## City of Albuquerque

November 30, 1981

RE: 2201 CHELWOOD DRAINAGE REPORT

A review of the referenced drainage report has resulted in the comments listed below. The numbers indicated refer to the Drainage Report (DR) and Construction Plan (CP) Checklists:

LANDSCAPING PLAN

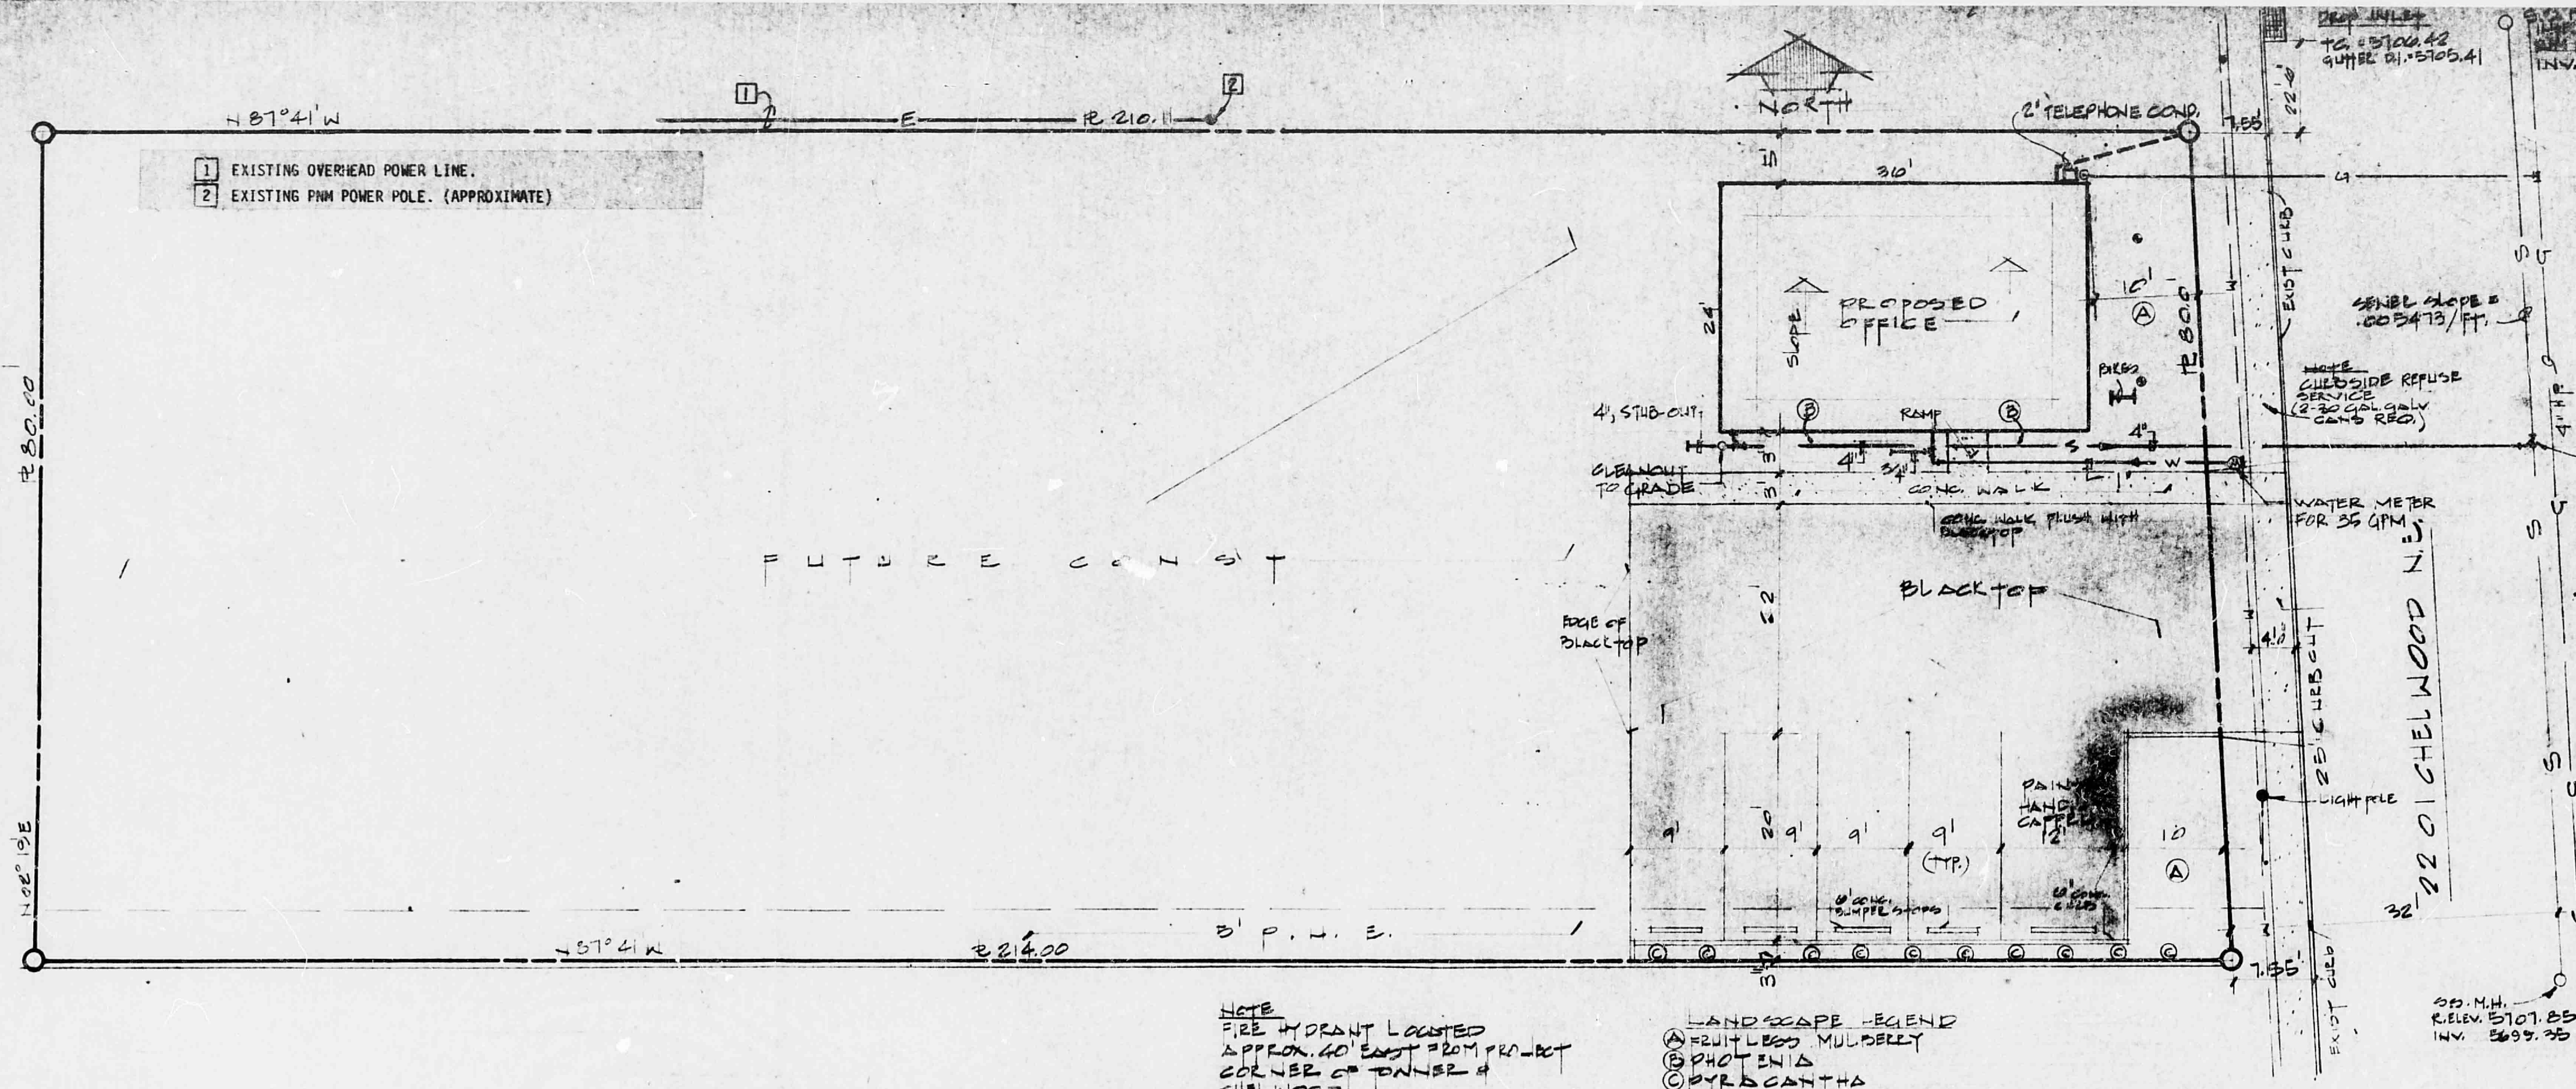
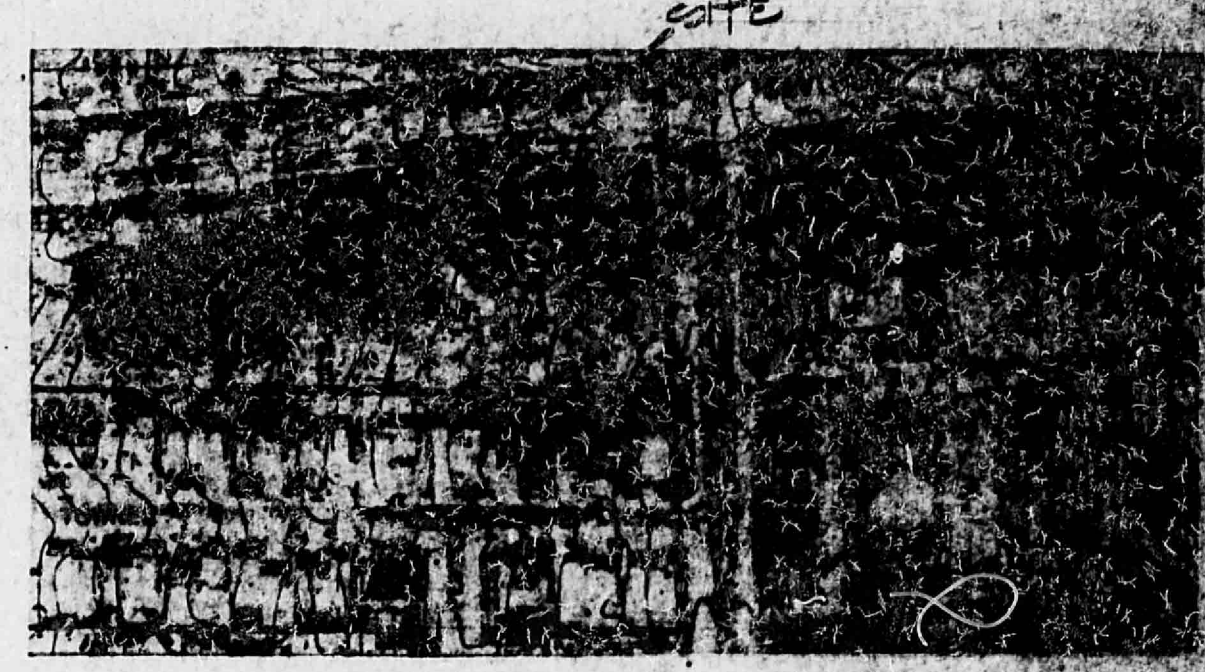
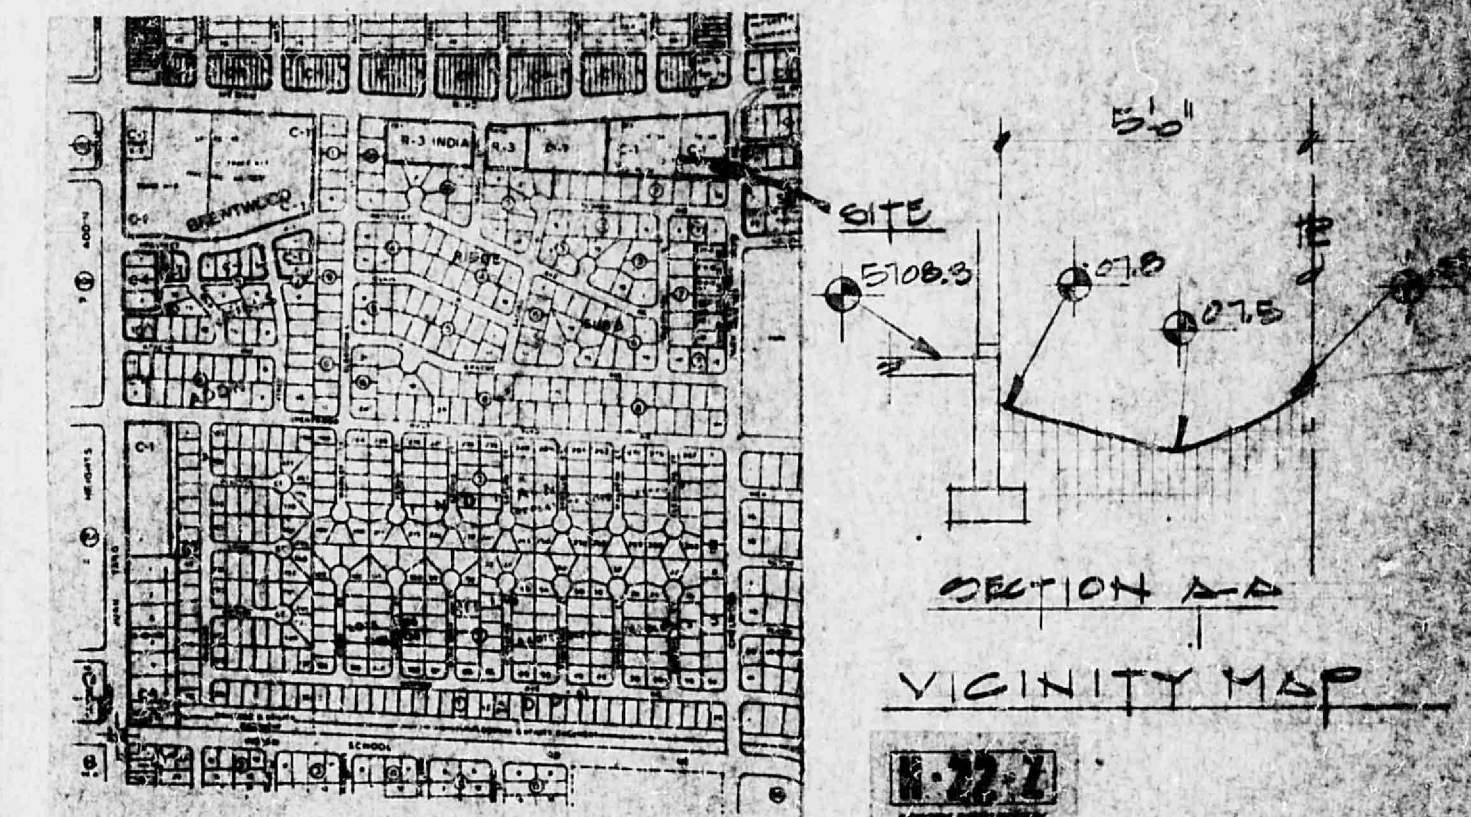
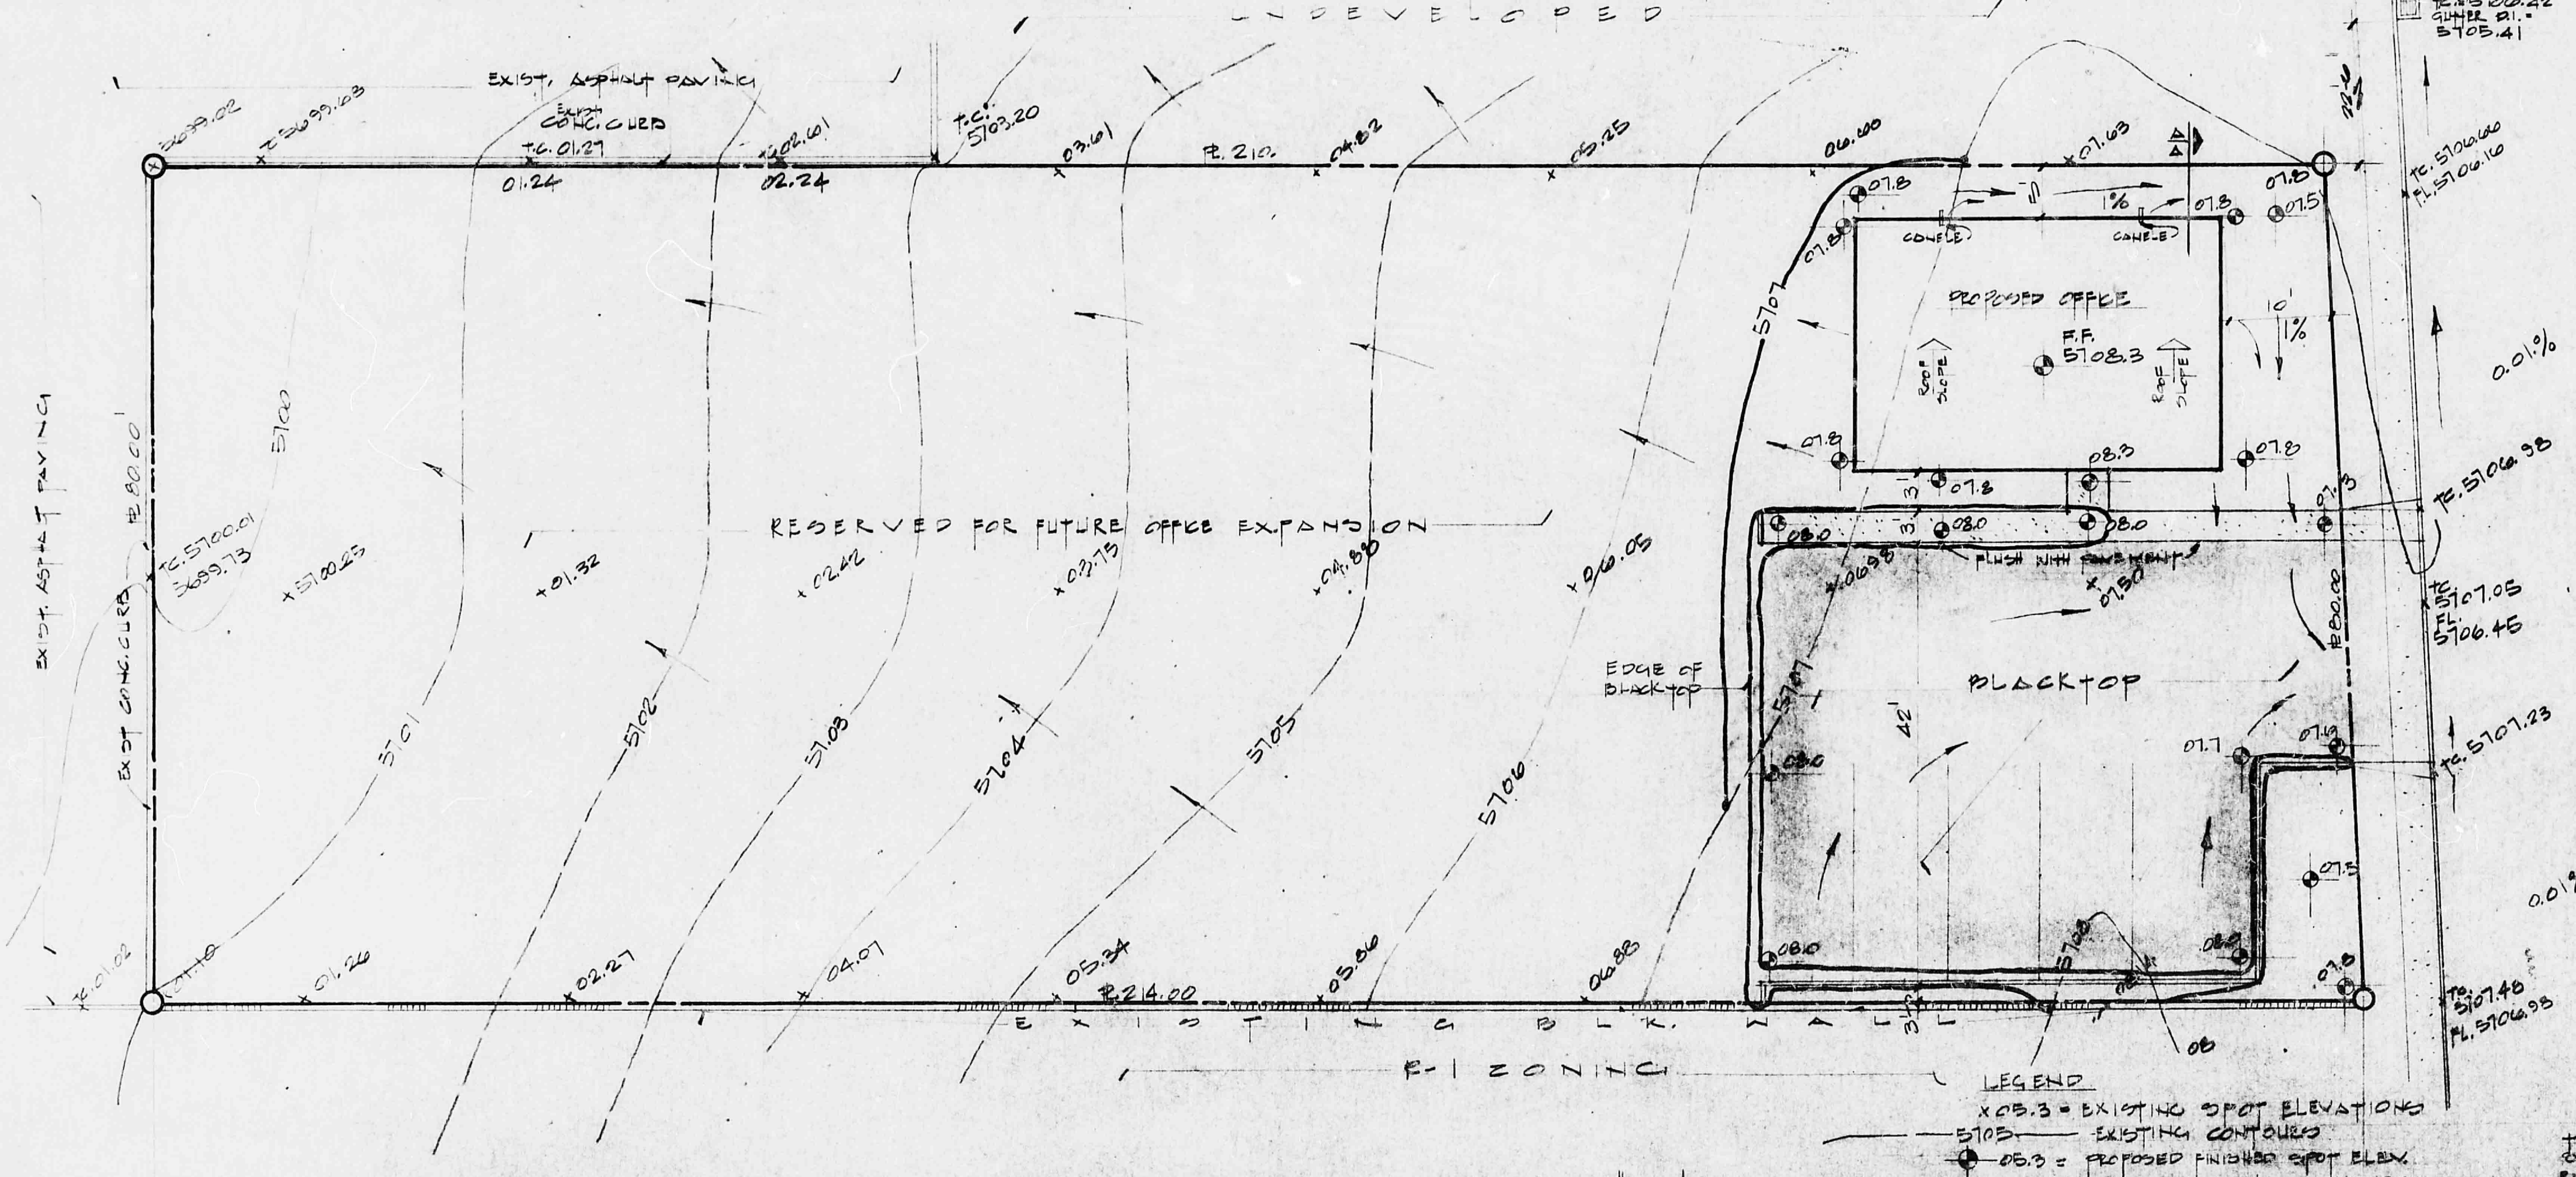
1. DR # 4 - Delineation of site on pertinent Flood Hazard Boundary Map.
2. DR # 7 - Delineation of off-site contributing watersheds on Albuquerque Ortho-Topo Area Maps.
3. DR # 13 - Calculations showing on-site undeveloped and developed flow volumes and rates.
4. DR # 15 - Adequate treatment of on-site flows. Because of the size of the development, free discharge is probably appropriate. However, downstream capacity must be demonstrated.
5. DR # 21M & CP # 14 - Detail of swale along north and east side of building.
6. CD # 17 - Location of canales, or roof drains identified.
7. The Plans indicate that this is the first phase of development. With a significant westerly drop in grade, what drainage provisions are anticipated for future expansion?
